Response to Section 51 advice for Thanet Extension

Thanet Extension Offshore Wind Farm

Appendix 1 to Response to Section 51 Advice:
Section 44 consultees

Land Plan (Onshore)

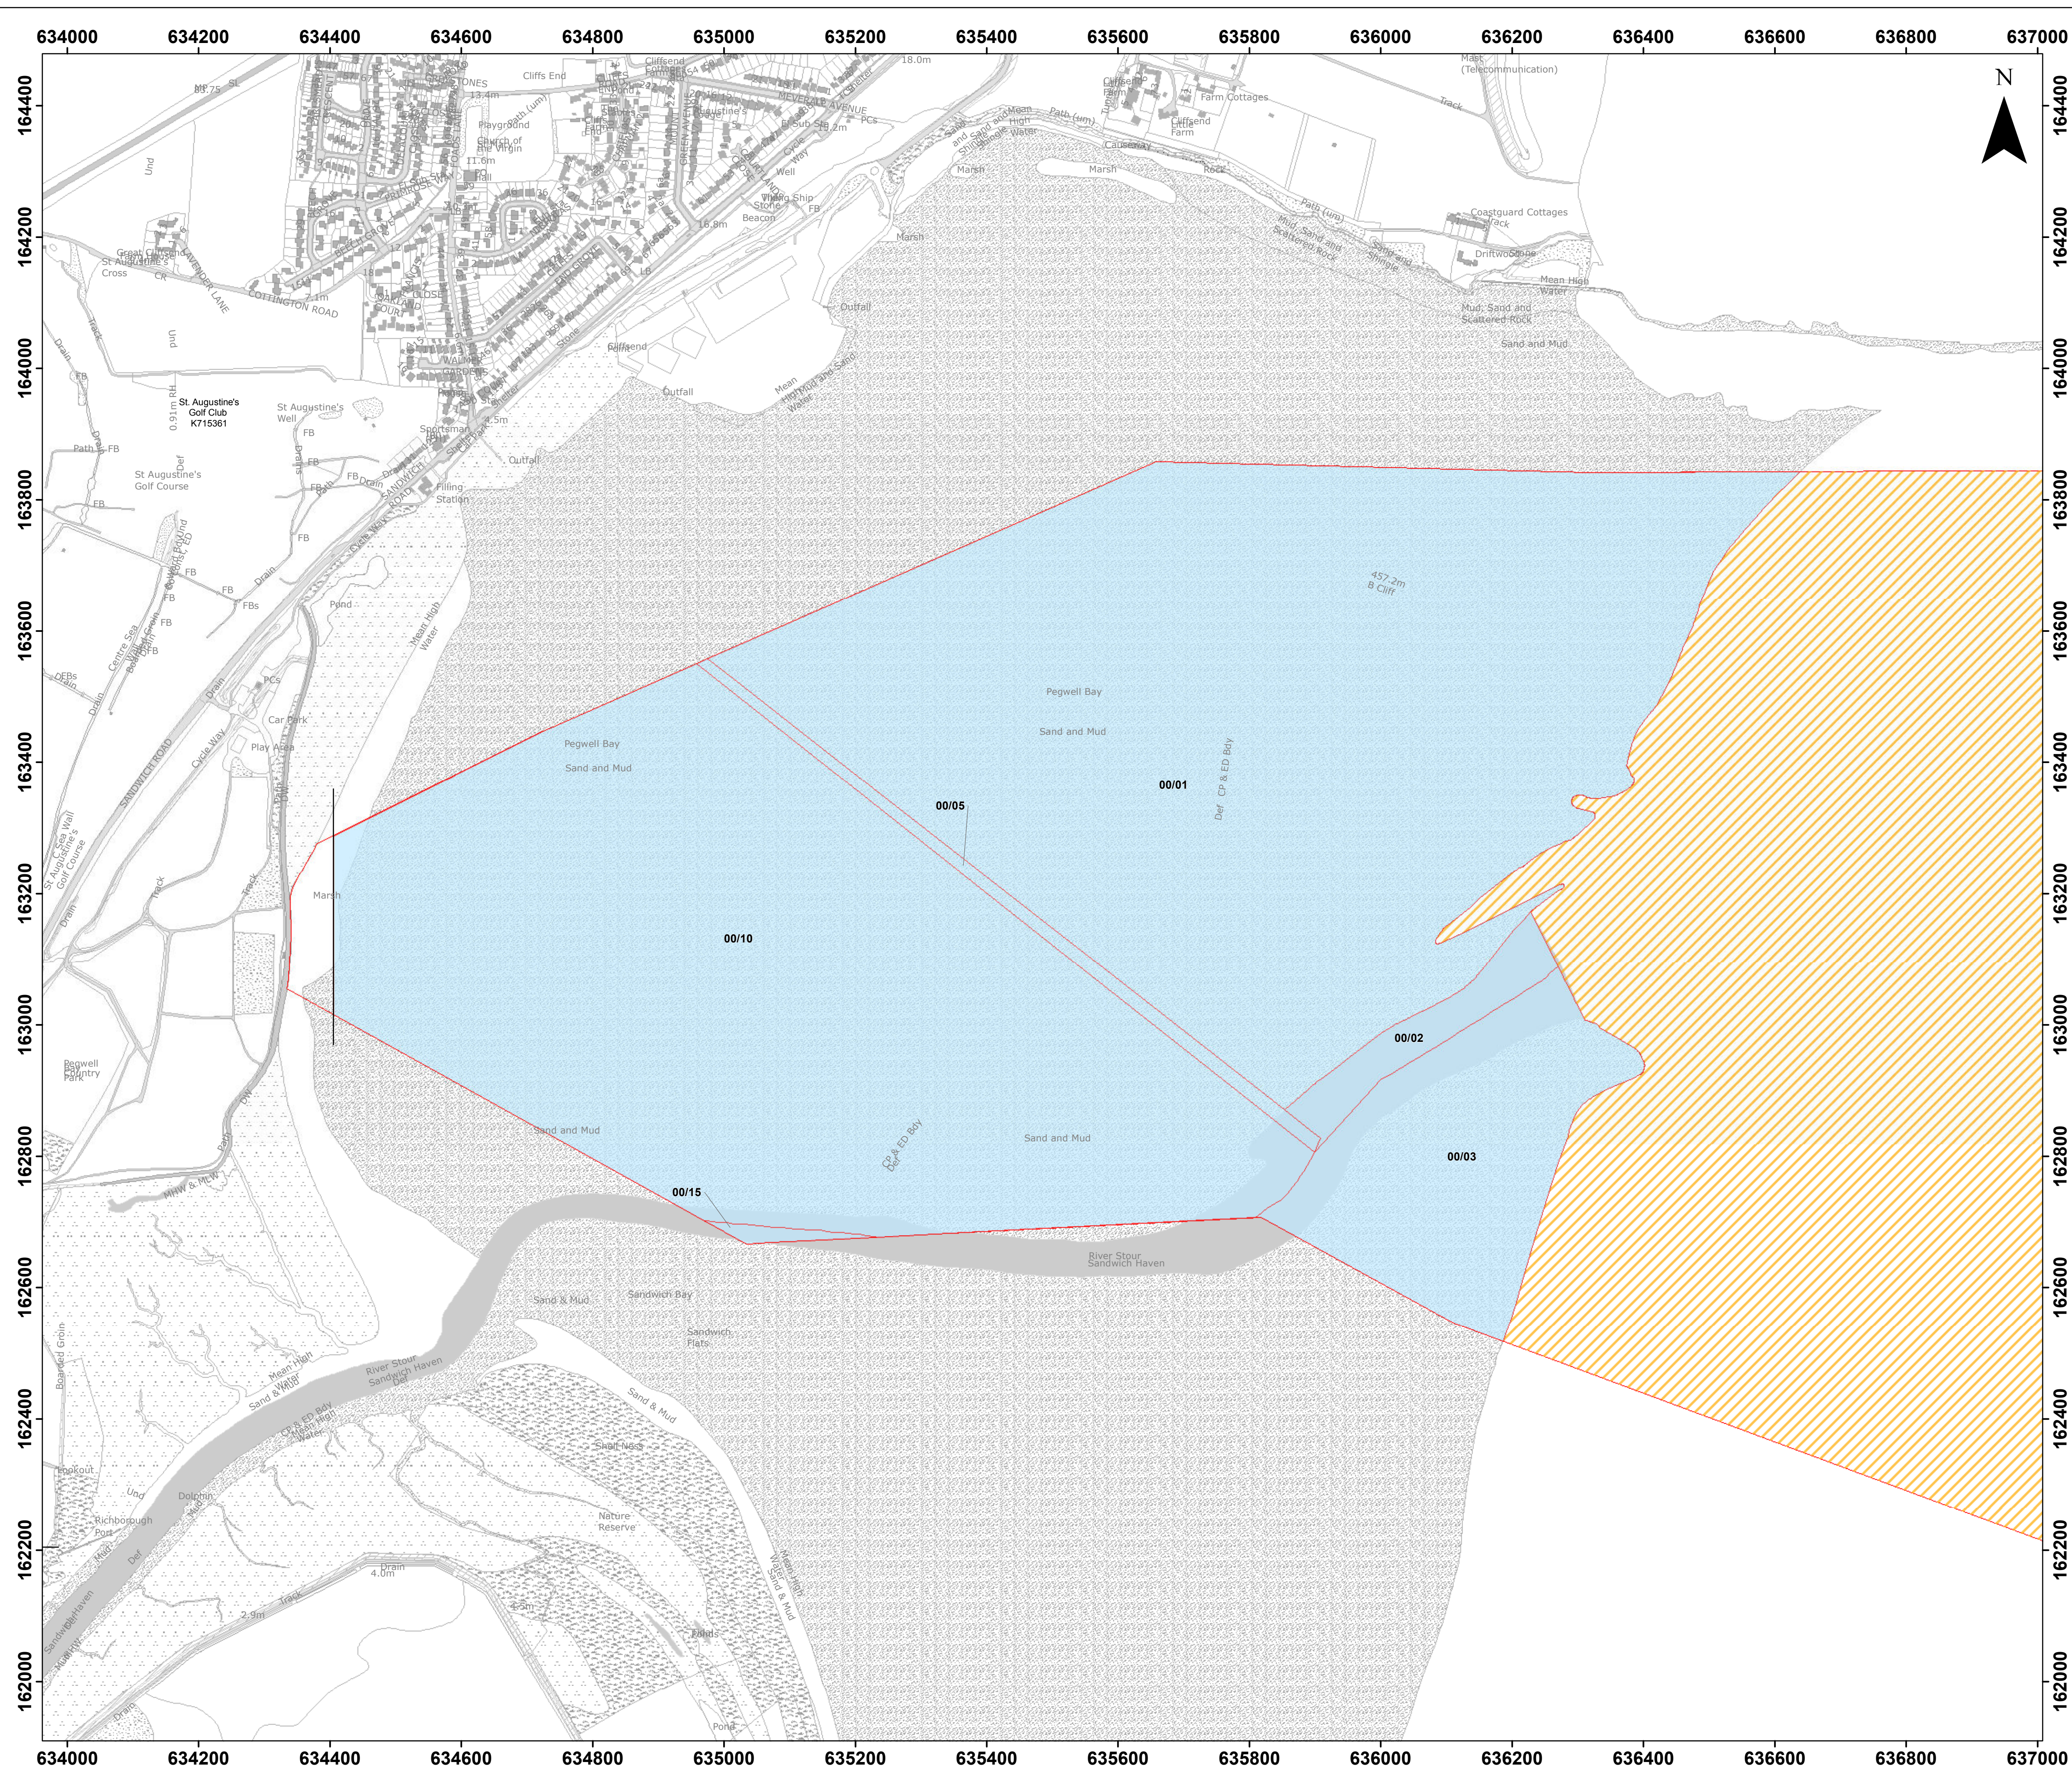
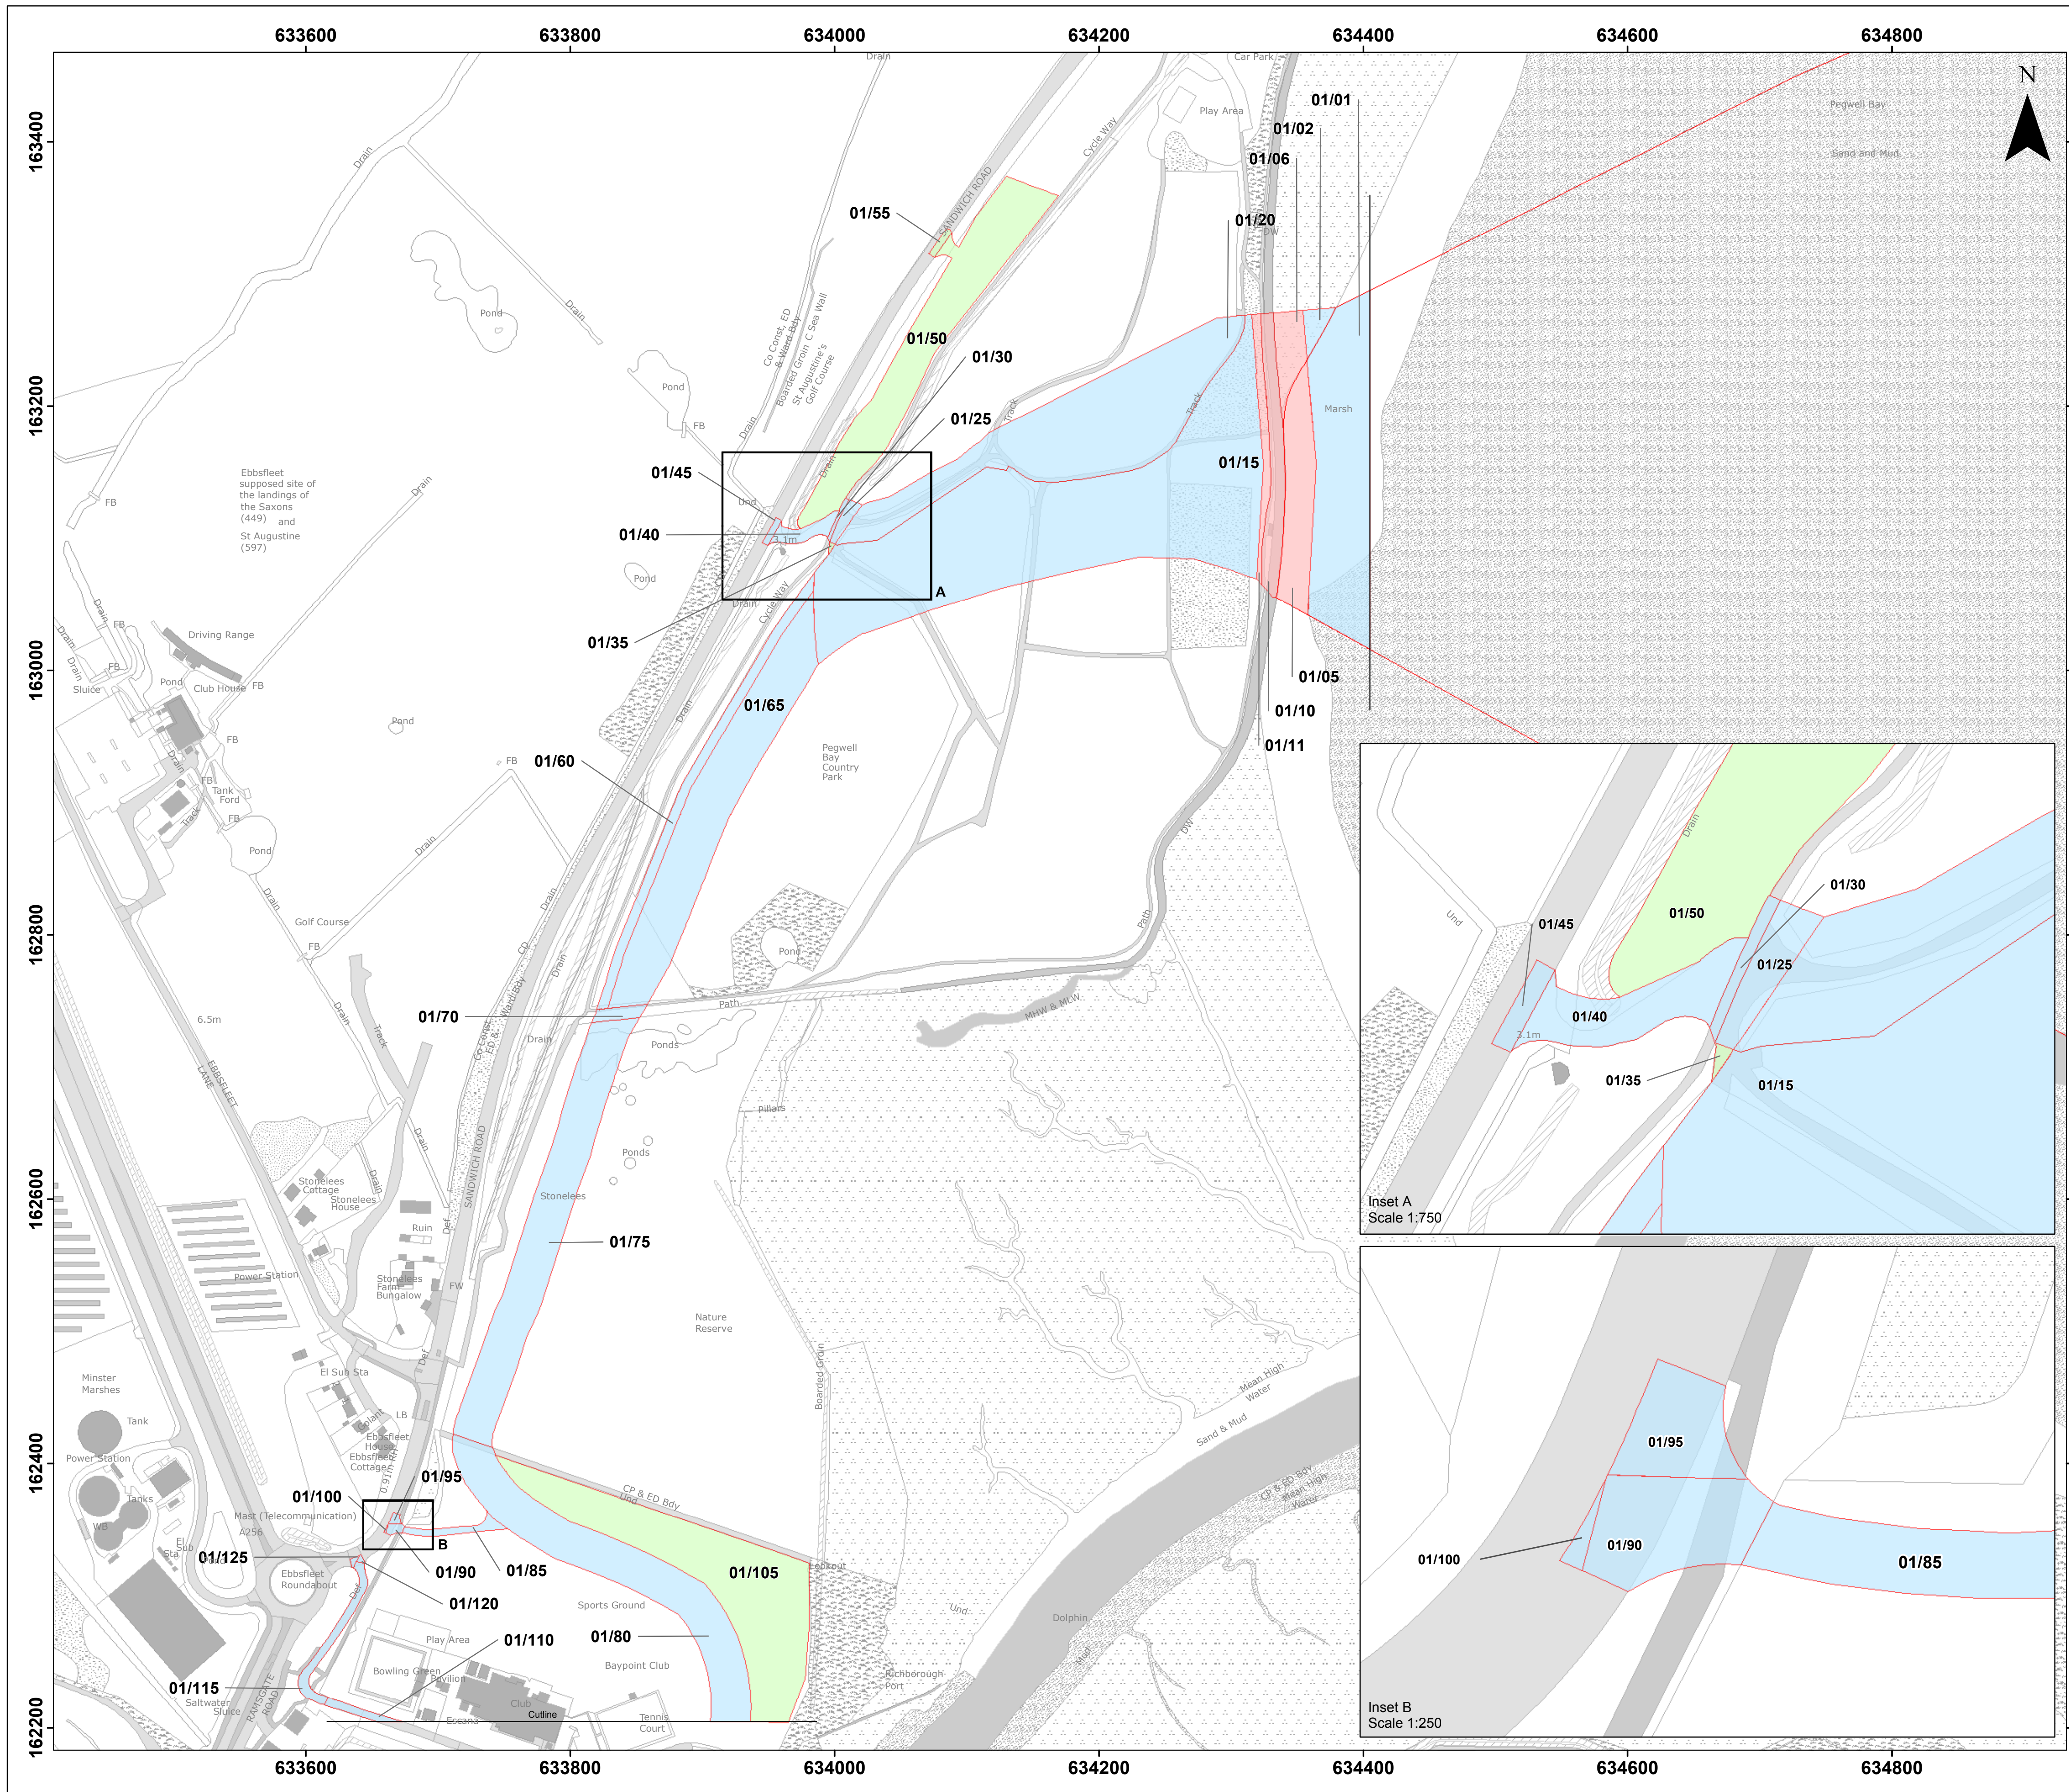
In the legend 'Cable route options' does not describe what rights are being sought.	The legend has been amended to read 'Cable route options – Permanent acquisition of new rights'.
No landmarks or road names are identified on the land plans	This has been updated on Land Plans and specific land mark names, where needed, have been added to the OS mapping.
The scale is not in compliance with Regulation 5(4A) of the APFP Regulations, for the onshore plan sheet 0.	This sheet has been changed to 1:2,500.
